From: [REDACTED]
Sent: [REDACTED]
To: [REDACTED]
Subject: [REDACTED] EP/74/20/HH

From: [REDACTED]
Sent: 07 August 2020 10:00
To: Iqraa Malik
Subject: RE: Request for further information EP/74/20/HH

Ordnance Survey © Crown Copyright 2020. All Rights Reserved.
 Licence number 100022432
 Plotted Scale - 1:500. Paper Size - A4

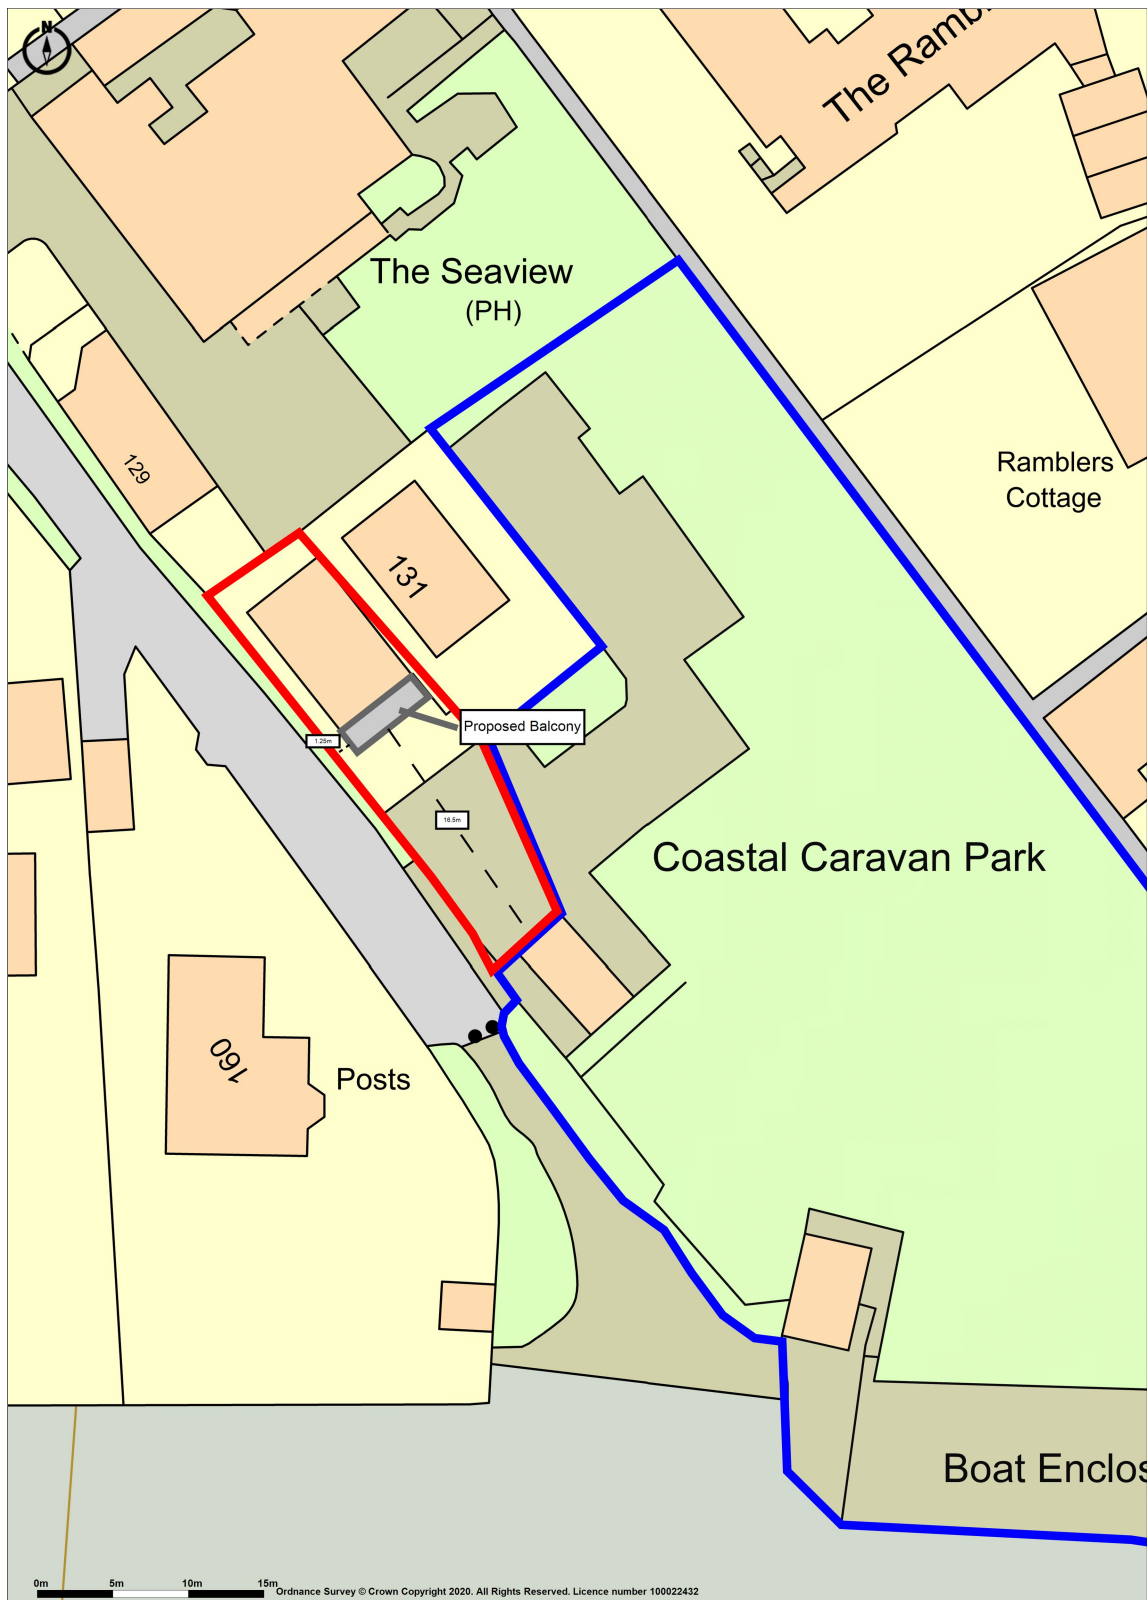
This does seem a little unreasonable as the scale of the site plan at 1:500 shows the building abutting the eastern boundary and there is no change to the rear of the property? I cannot see in this instance how these annotations will benefit members of the public in understanding the proposal or the officers assessment. If you feel differently, I would be grateful if you advise why?

Unfortunately your application is still invalid as you require dimensions on your block plan from the proposed extension to all site boundaries. Please amend or with your permission, we are able to amend this for you.
